Site: Stonestreet Green Solar
Proposal: Application for grant of Development Consent Order ('DCO')
Issue: Written Representation

In accordance with the Planning Inspectorate's Rule 8 letter dated 28/11/24, this letter – constitutes Ashford Borough Council's **Written Representation** ('WR') and follows published guidance. It clarifies and updates the Borough Council's views already set out in its **Relevant Representation** ('RR') (RR-018).

Project Name:  
 Stonestreet Green Solar  
 Drawing Title:  
 Illustrative Layout Plan  
 Sheet 2 of 5  
 Drawing Number:  
 142-02-01-pg2  
 Scale: 1:2,000@A1 APFP Reg. 5(2)(a)  
 Produced: RC Checked: Quod Date: November 2024 Version: 02

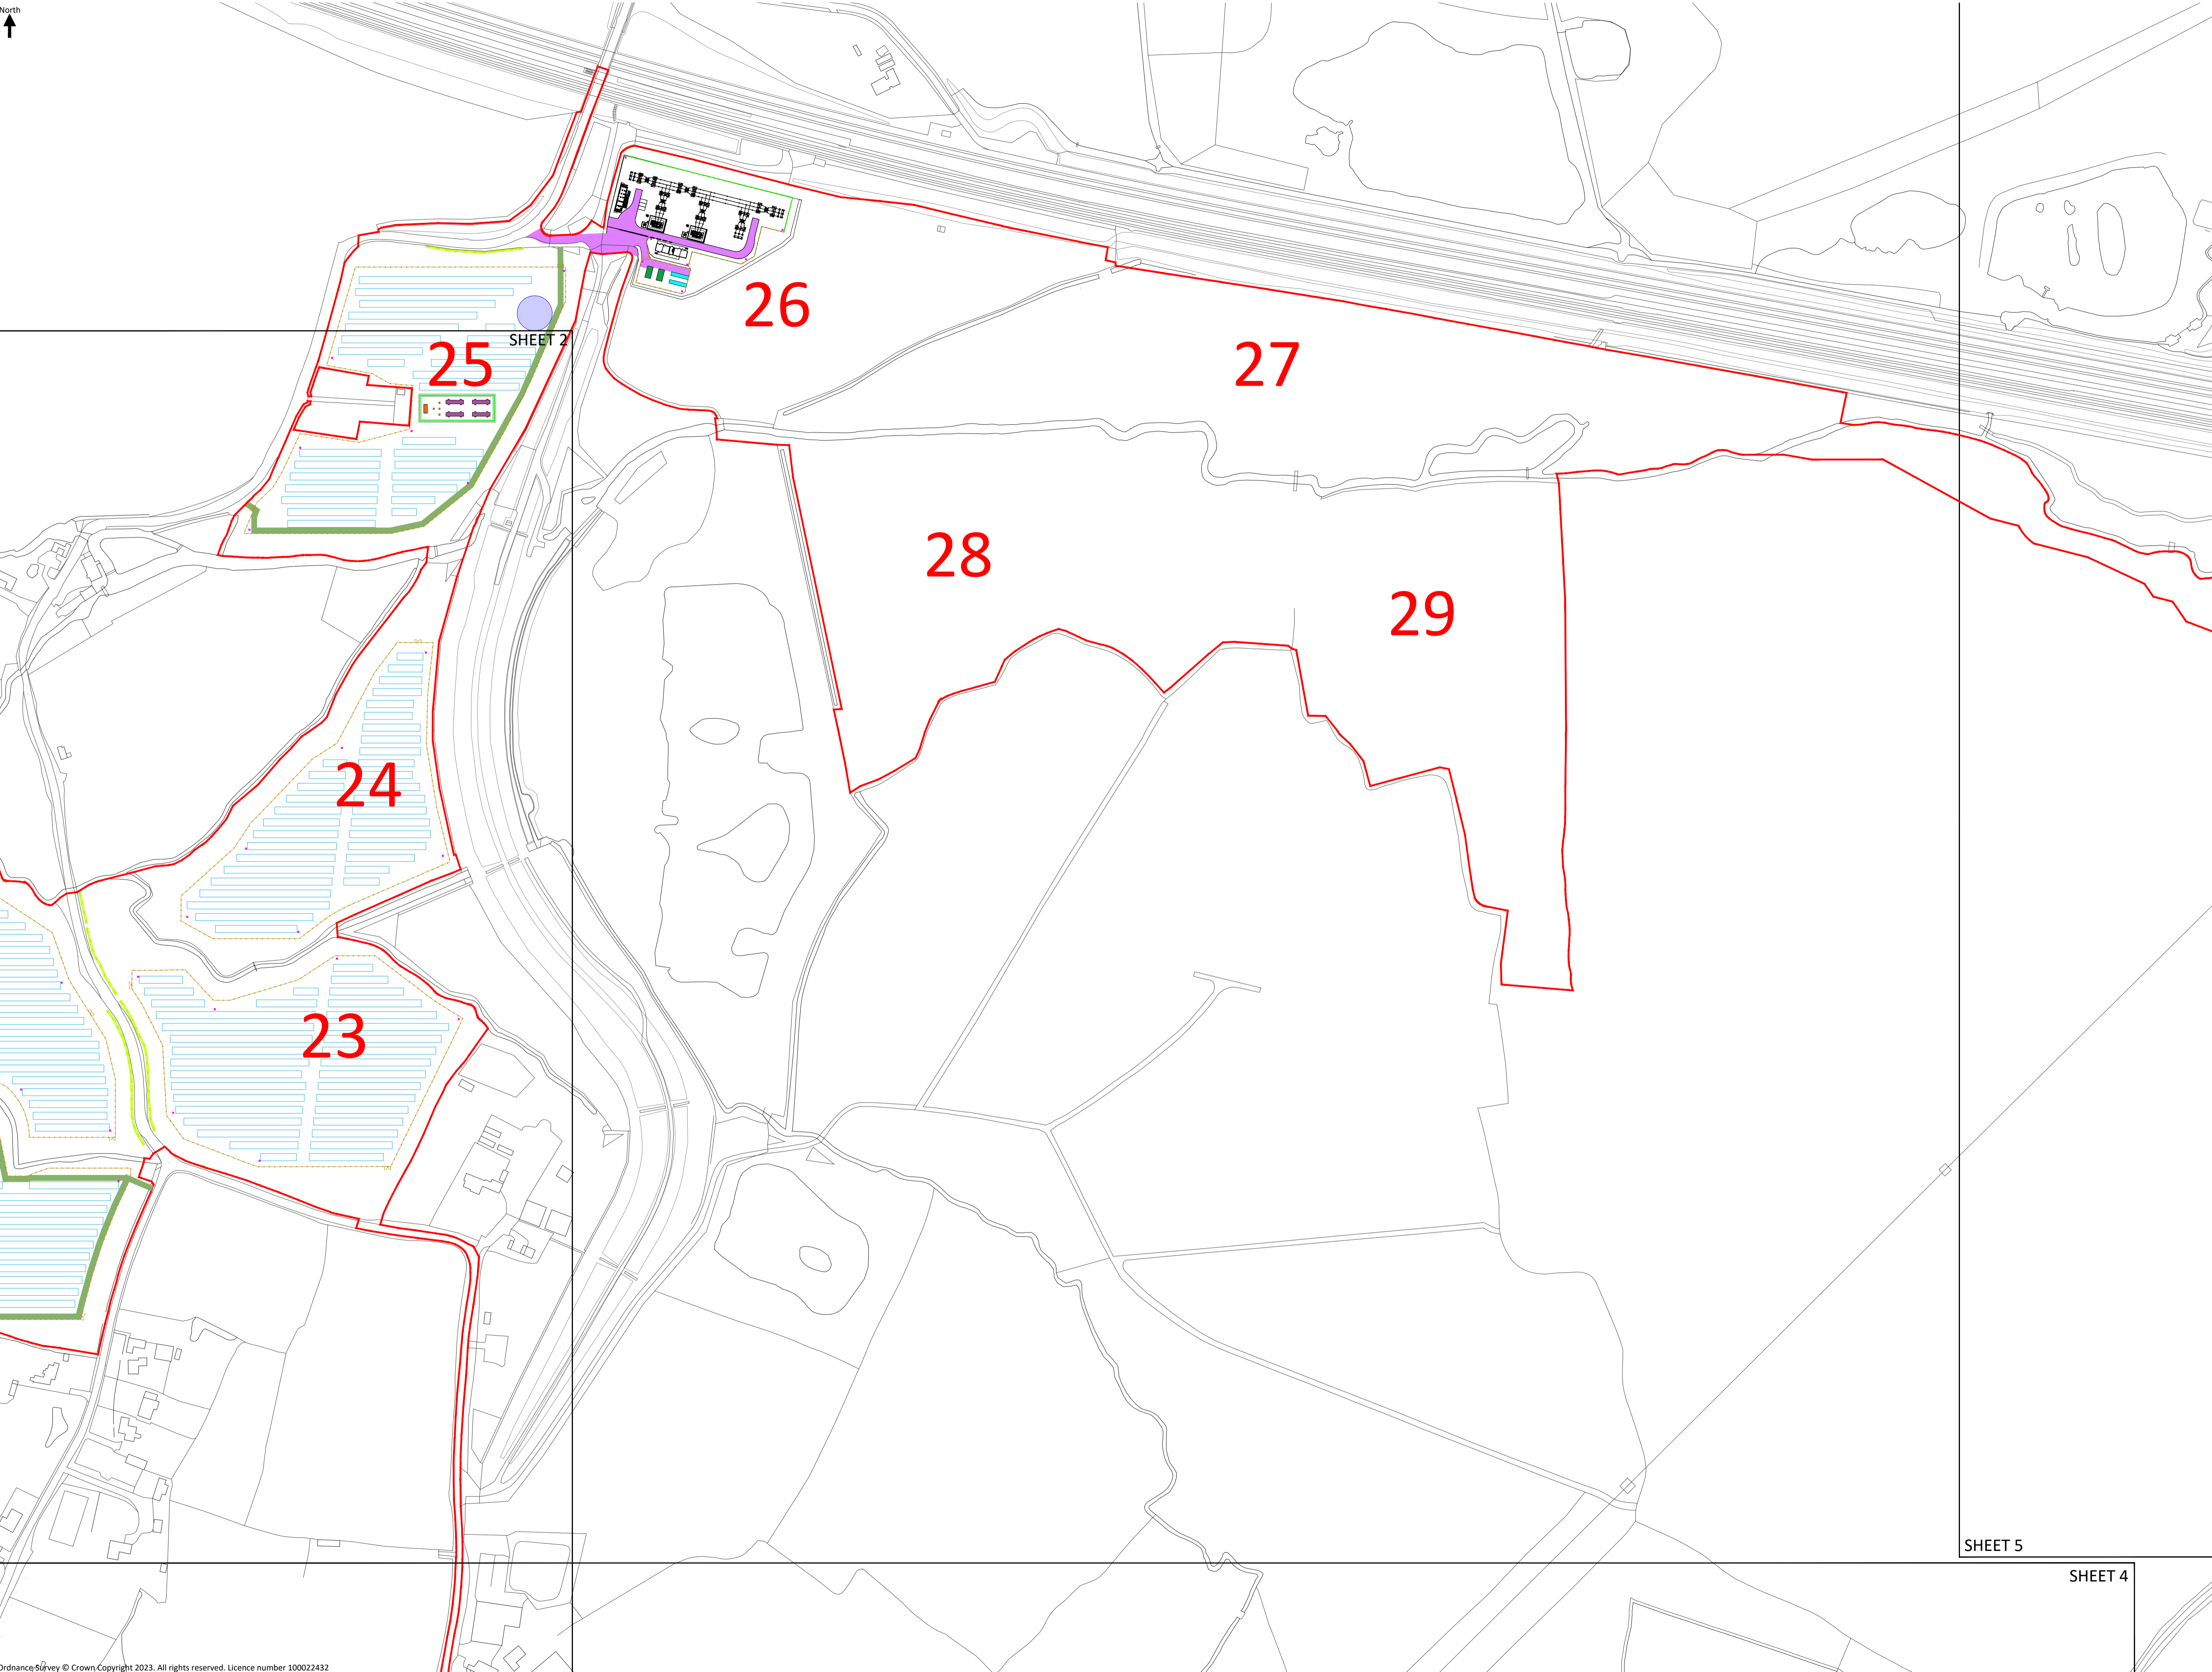
12. As the Council's LIR identifies, the development proposed to occupy Fields 1 to 19 would form a substantial largely unbroken continuous area of solar panels arrays and associated electrical infrastructure that will include Battery Energy Storage Systems (BESS) and this will have a significant adverse residual landscape and visual impact on the Aldington Ridge Local Character Area.

13. The Council requested removal of solar development from Fields 10 and 12 because these effects would be located on the crest of the Aldington Ridge that is highly visible from the PRow network and from the Station Road approach southwards towards the village. The Aldington and Bonnington Neighbourhood Plan ('A&BNP') Policy AB4 viewpoint 1 establishes the importance of this view up to Bank Road.

17. Given the significant adverse residual landscape and visual effects, the Council also suggested to the Applicant the importance of breaking up the expanse and intensity of the Field 1 to 19 area.

24. The Council considers that enhanced softening, primarily in the form of increased physical separation, should be provided to the south and south-west of Field 20 to moderate the impacts of solar infrastructure on users of PRow AE474 that connects Goldwell Lane to Church Lane. This area for proposed solar generation dips away to the north but the southern boundary is especially important because of its proximity to PRow AE474. A&BNP Policy AB4 viewpoint 2 identifies the importance of the views when using the route in both directions. The Council remains concerned that the scheme will necessarily impact on the experiential qualities enjoyed by PRow users because its qualities include;-

26. As set out in the Council's LIR, the recommendation by Historic England ('HE') to reduce the harm to the setting of Stonelees, a Grade II* listed building, by retracting the proposed development at the southern ends of Fields 3 and 7 is one that the Council supports as part of 'softening'.
